## Report of the Head of Planning, Transportation and Regeneration

**Address:** 174 Aylsham Drive Ickenham UB10 8UF

**Development:** Details pursuant to the Discharge of Conditions 3 (Materials), 4 (Landscaping), 6 (Sustainable Water Management), 8 (Construction Logistics Plan), 9 (Step Free Access) of planning permission ref. 35924/APP/2020/2270, dated 29/09/2020 of which varied the main permission ref. 35924/APP/2020/991 dated 08/06/2020 (Two storey, 1-bed attached dwelling and two storey rear extension involving parking and amenity space)

**LBH Ref Nos:** 35924/APP/2022/409

No.	Date:	Revision Notes:	Initials:	Notes:	Client	Drawing	External Works & Landscaping Plan	Revision
A	03/02/2022	Landscaping notation and detail added			MR & MRS BEN GASCOYNE		20 BGAR 401	A
					Project		174 AYLSHAM DRIVE ICKENHAM UB10 8UF

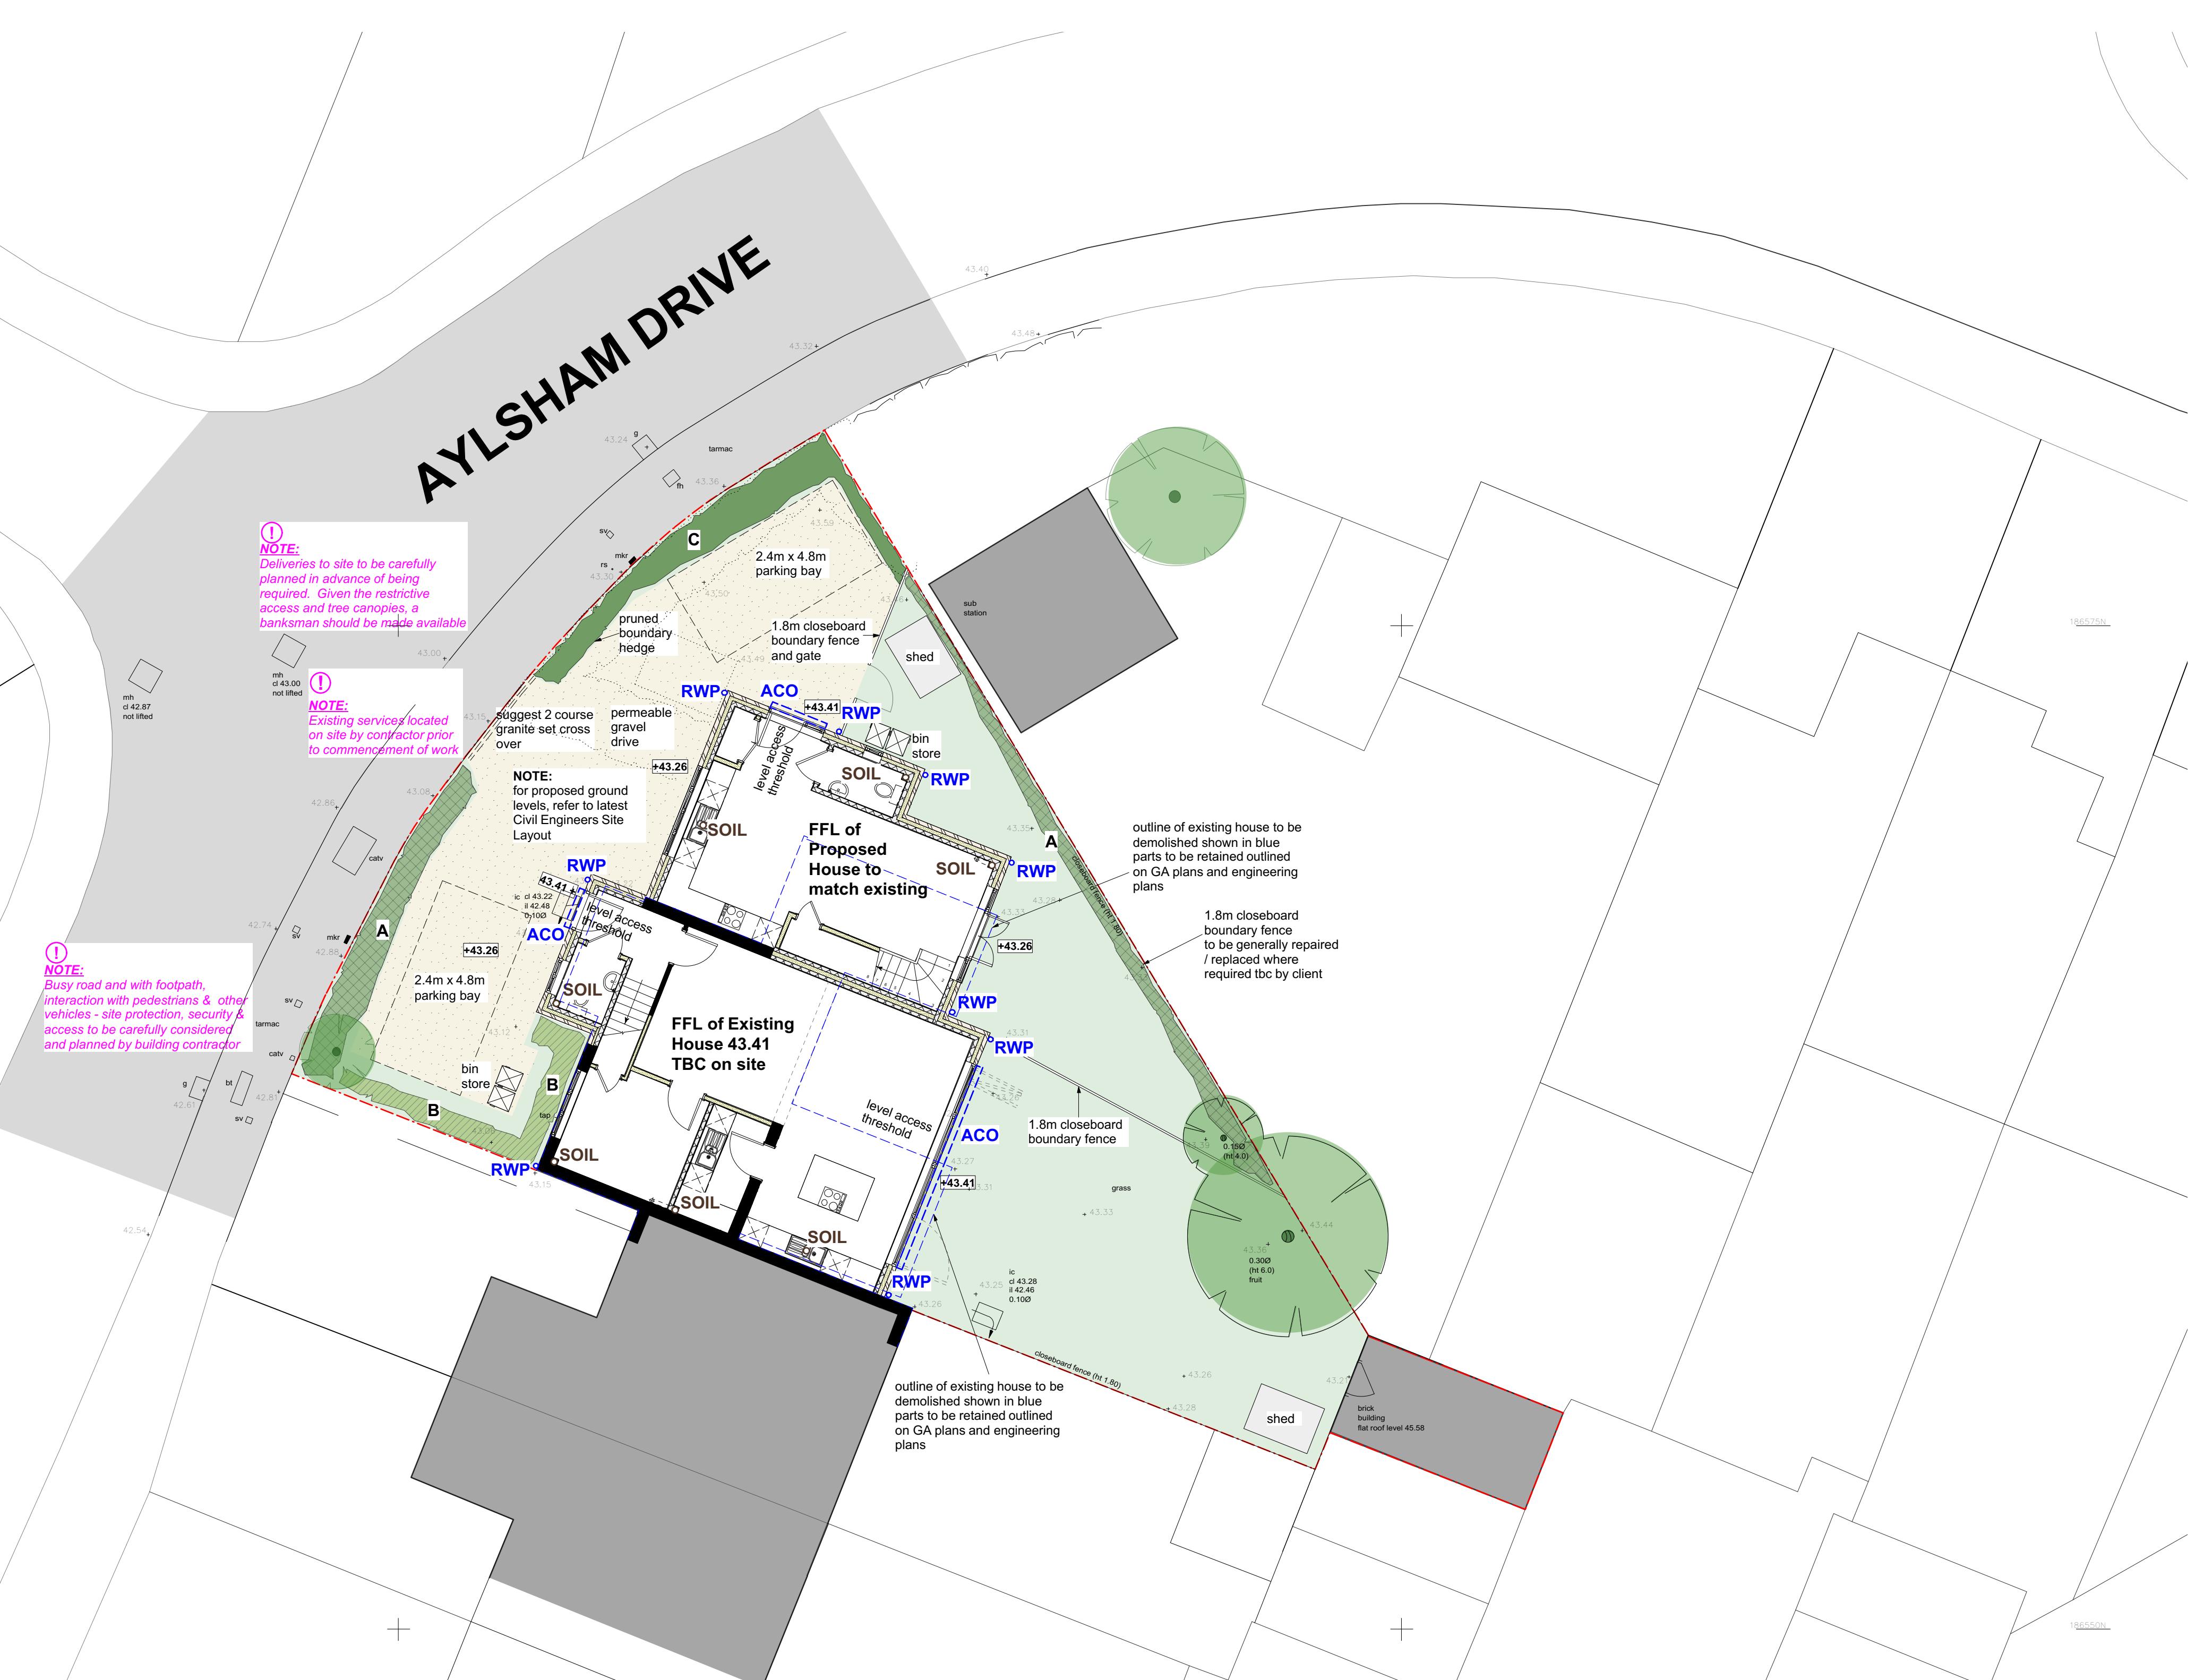
The Councils Tree/Landscape officer has reviewed the submission and considered the landscape proposals to be vague and lacking appropriate detail and specification.

1. What is the front boundary treatment? In addition to hedge planting some sort of permanent boundary definition is required in the form of a low fence / wall/ railings.

2. The specification and plant schedule of the mixed hedges (plant group A) requires amendments. The use of

blackthorn within the mix in this location is inappropriate. The plant schedule should include the size of the plants (at the time of planting), the size of the container (or whether bare-root), the numbers of each plant or the % mix.

3. The plant specification of the plants in schedule B includes a random mix of incompatible large and small growing shrubs, including both sun-loving / shade tolerant species. Plant numbers/m<sup>2</sup> will vary according to species.

4. Reference is made to the work being carried out 'in accordance with good horticultural practice'. What does

this mean? More detail required.

5. Permeable bound gravel has been specified. More detail (product /example?) required with reference to the correct sub-base (without which the surfacing will not be permeable).

In terms of hardstanding details, no details (specification, size, material) of refuse and cycle storages have been provided. It is proposed to have 1.8m high timber fencing on the side and rear boundaries which is acceptable. In terms of hard surfacing, the chosen materials (Gravel and Granite) could be acceptable but as above no specification has been provided to demonstrate the acceptability. It would appear no external lighting is proposed which is considered to be acceptable.

Redland, Double Roman interlocking tile:

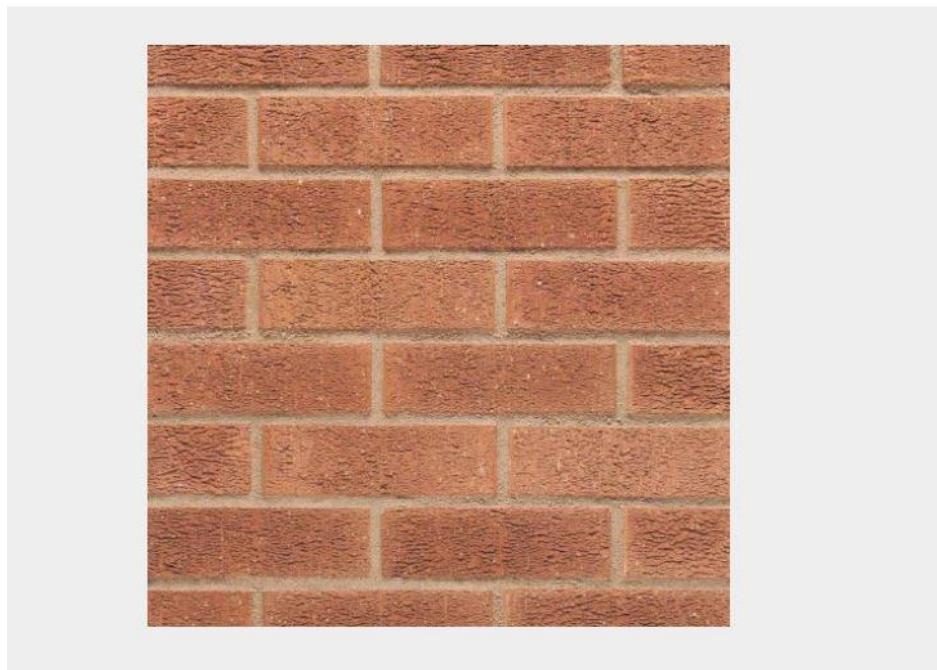
The document shows a photograph, make, product type and colour of the bricks and roof tiles of which are similar to those of the existing dwelling. However, it is suggested that the 'closest match' is proposed or the suggested material (as above). Had the condition been acceptable, commitment would have been sought by the applicant on the exact material (brick and roof tile) to be used. That being said, the proposed Redland Double Roman Tile and Weinerberger Arley Red brick, appears to be the preferred materials of which would be acceptable.
